### **Final Report - Corrections Required** **Application No. LUPL-25-0008**

**Report Date: 10/02/2025**

**Document Filename : 241010\_BLR Village C Land Use Plan.pdf**

# BANNING LEWIS RANCH - VILLAGE C

ISSUE RECORD

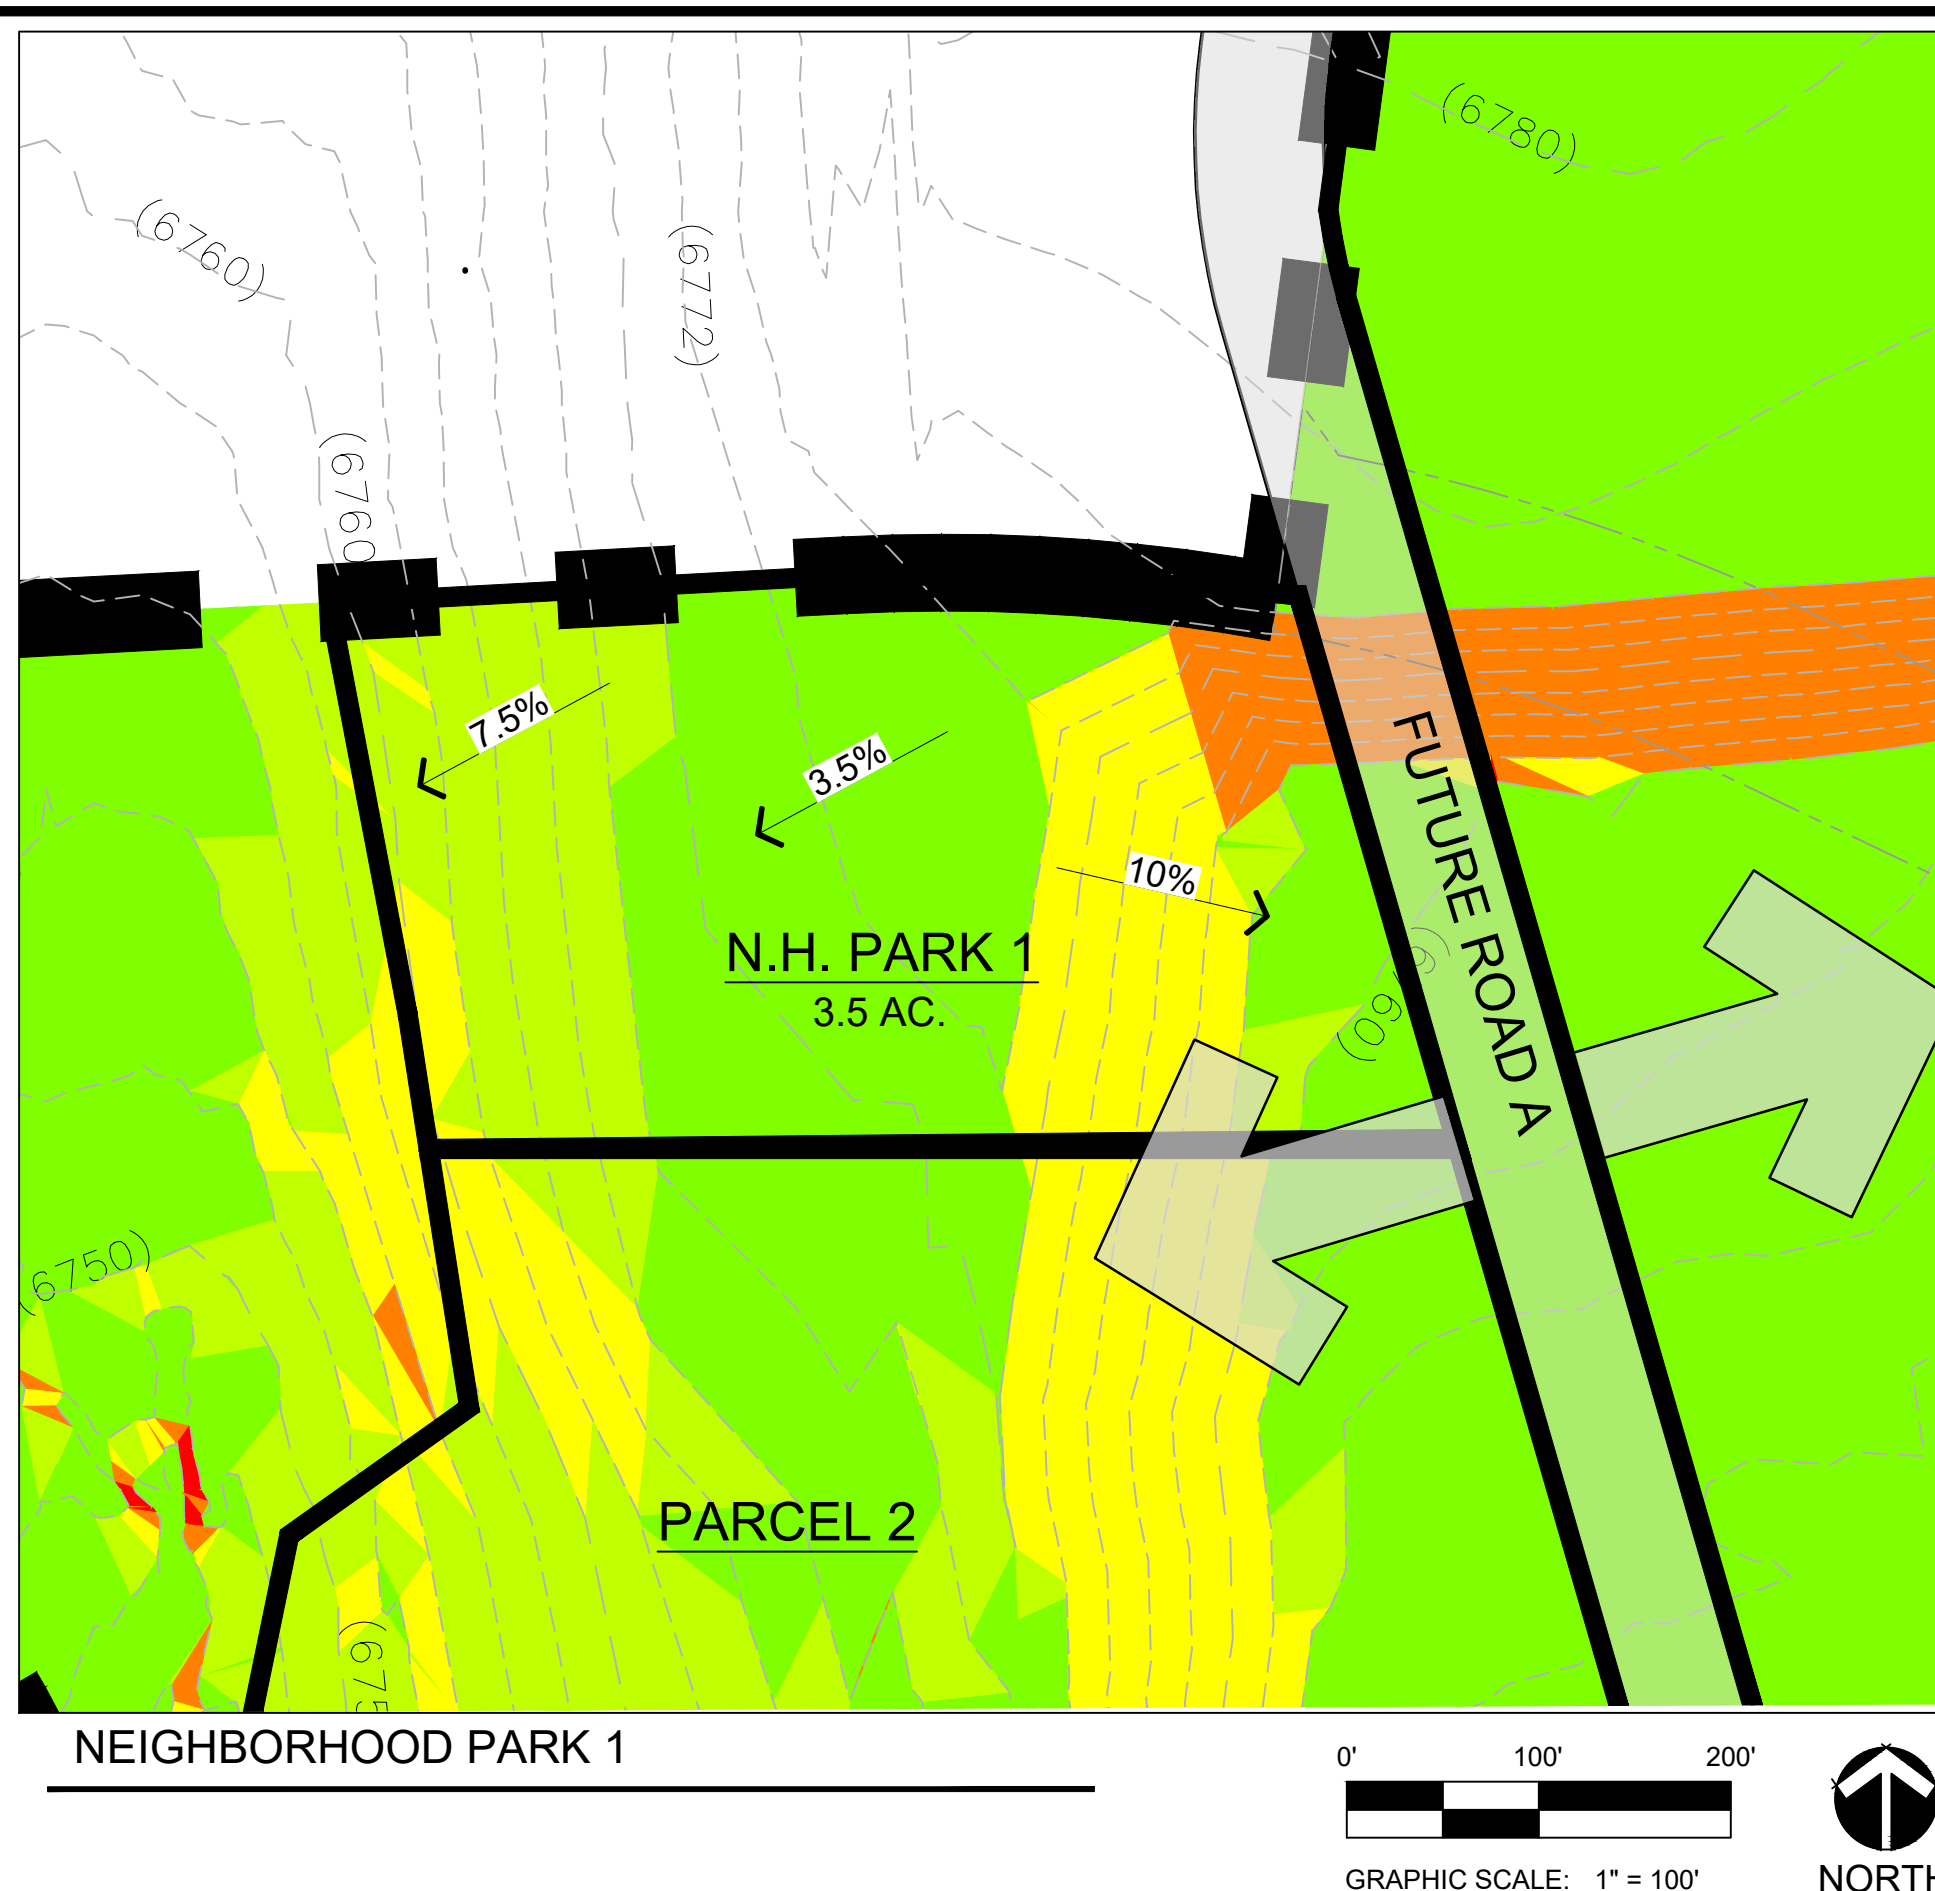
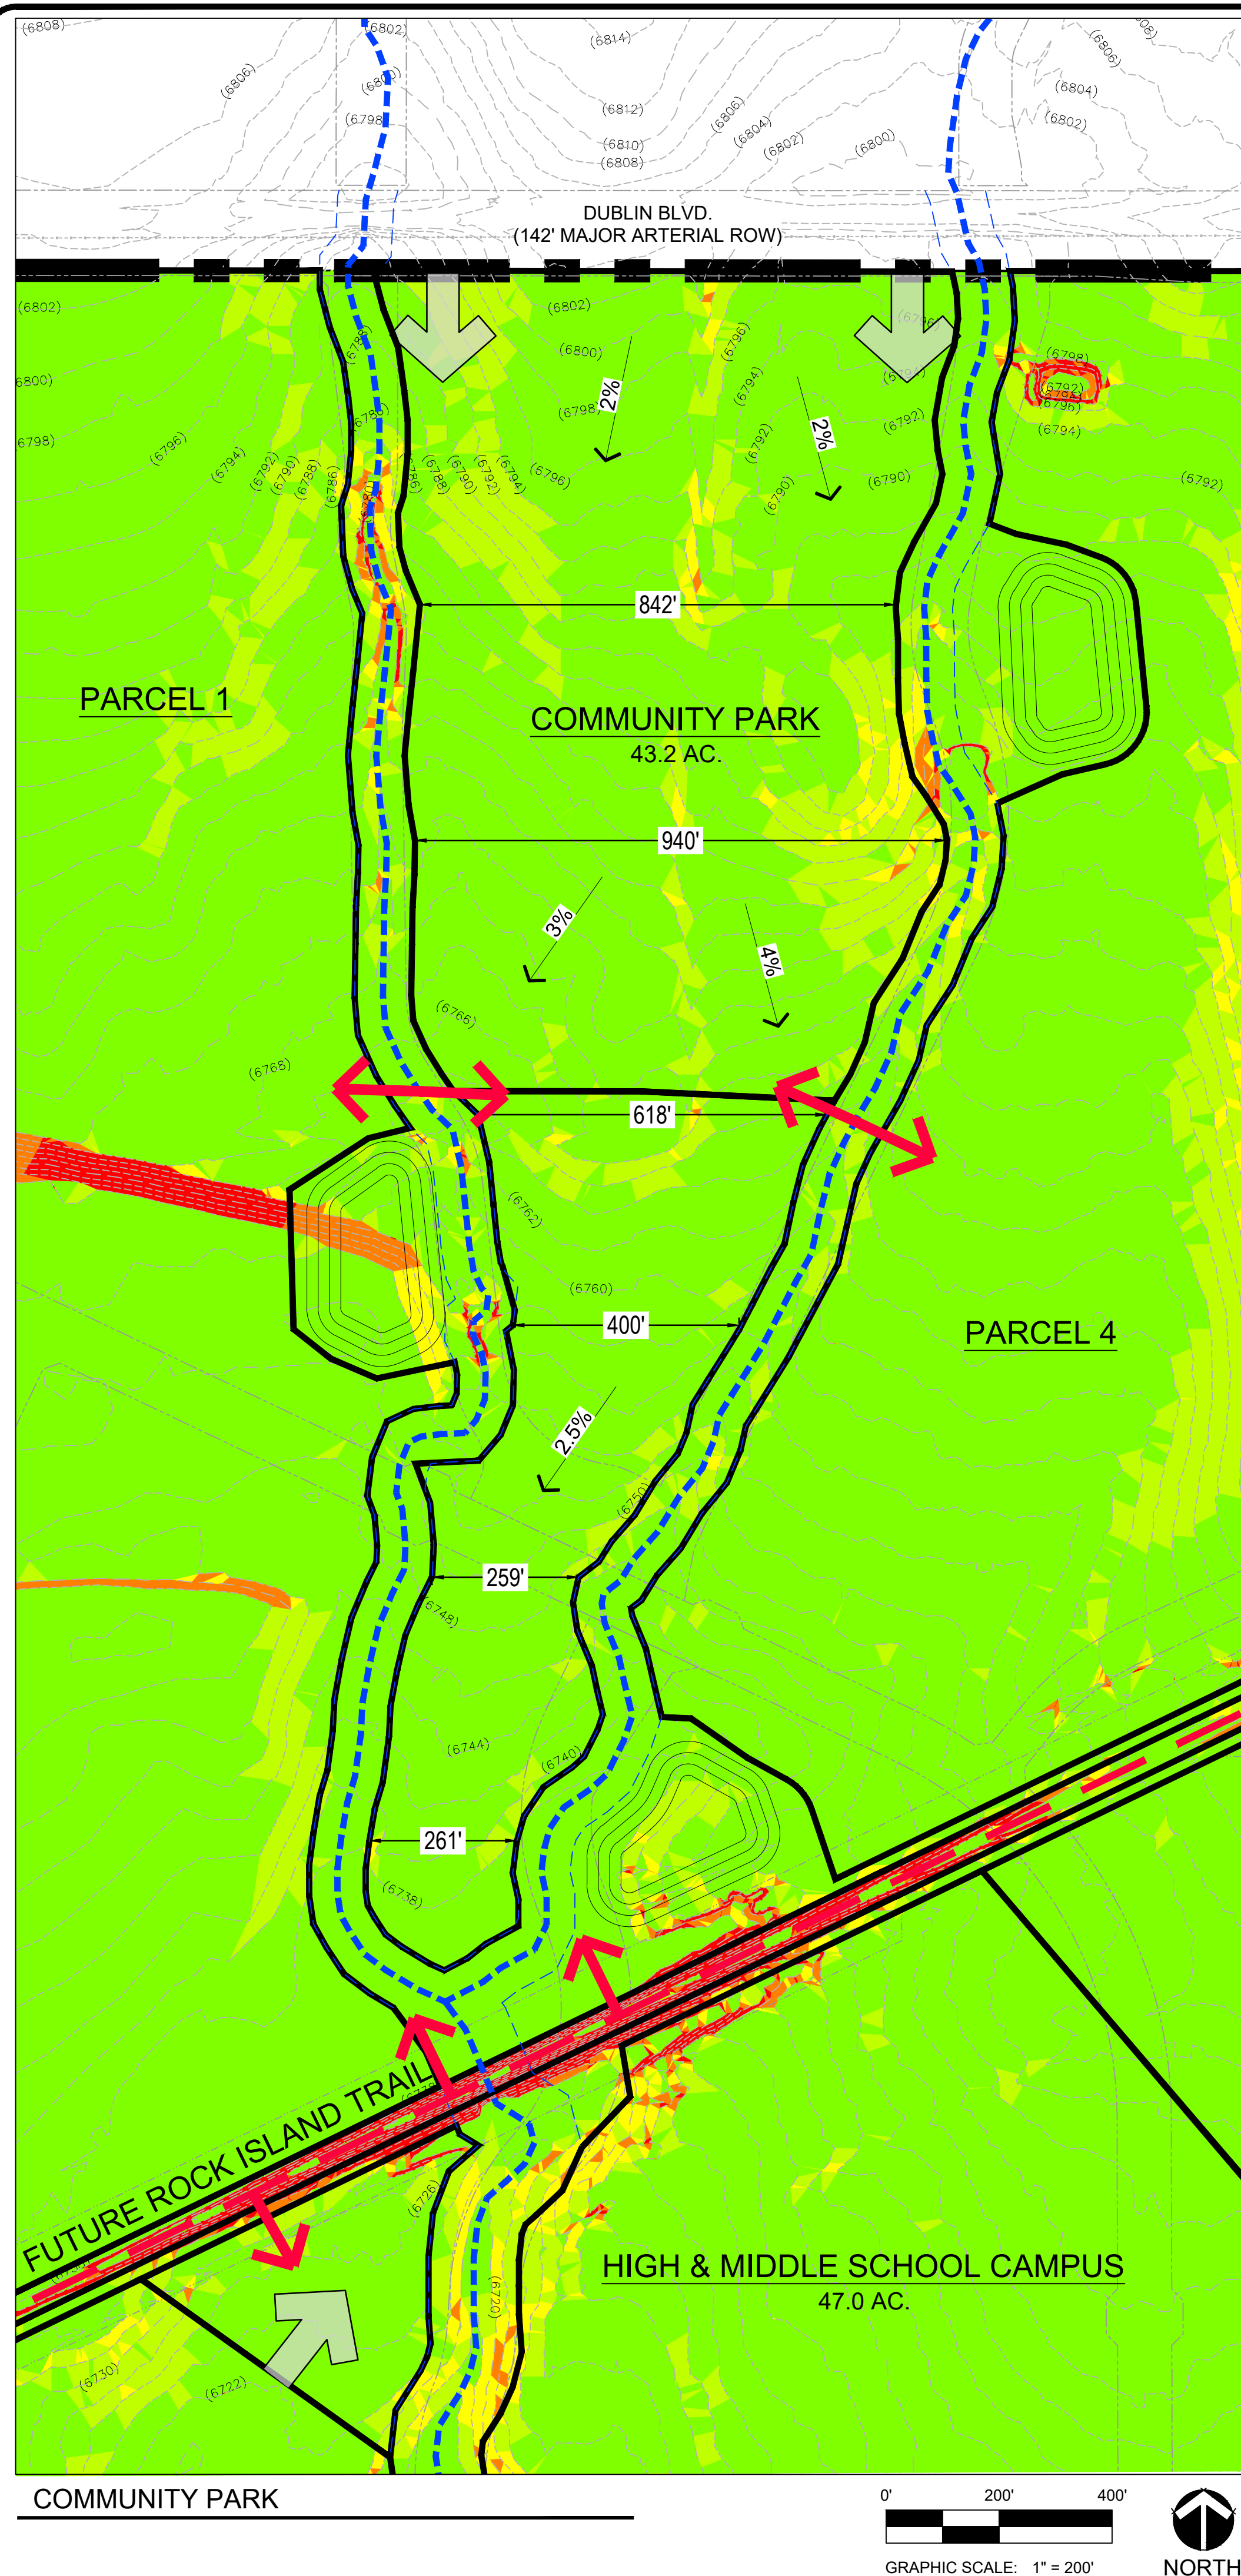
86	1	Tamara Baxter : Planning	El Paso County has not provided rereview comments. Upon receipt I will email them to you or re-run resubmittal report.
87	1	Tamara Baxter : Planning	Staff reserve the right to provide additional comments with subsequent resubmittal.
70	2	Caroline Miller : Planning	Please revise cells to match above unit counts.

<b>Comment ID</b>	<b>Page Reference</b>	<b>Reviewer : Department</b>	<b>Review Comments</b>
71	2	Caroline Miller : Planning	<p>With the change to Community Park acreage, staff would like to understand the road connections for the Community Park site and the residential area to the south. What is the thought for the road design? Will a connector road be built through the Community Park site, connecting to the residential area, thereby limiting the Community Park acreage to a full-access public road?</p> <p>In addition, will there be any other road access points off of Dublin, or just the Community Park area? Feel free to reach out to the reviewer to discuss in a meeting if preferred.</p>
72	2	Caroline Miller : Planning	Parks is awaiting feedback regarding the developer building the Community Park, then dedicating it to the city. A Community Park amenity list was provided in April 2025 to help the conceptual feasibility discussions. Notes will likely be added to this LUP in the future, upon developer response.

75	2	Tamara Baxter : Planning	What is the zoning for this area? Please call out.
76	2	Tamara Baxter : Planning	Please call out zoning for this area.
77	2	Tamara Baxter : Planning	Please call out zoning for this area. Should be reflective of the area shown in ZONE-25-0020
78	2	Tamara Baxter : Planning	Please call out zoning for this area. Should be reflective of ZONE-25-0021
81	2	Tamara Baxter : Planning	As noted on the cover sheet, SF detached are conditional use in the MX-M zone district
83	2	Tamara Baxter : Planning	Please clean up overlap so text is legible.
88	2	Tamara Baxter : Planning	Will future residential in this area be limited to the 3-156 du/ac, similar to R-Flex Med?
69	3	Caroline Miller : Planning	Please update Park Analysis to show 30 acre Community Park Site.
73	7	Caroline Miller : Planning	Please confirm that the potential wetlands will not pose a limitation to Community Park development over lot grading.
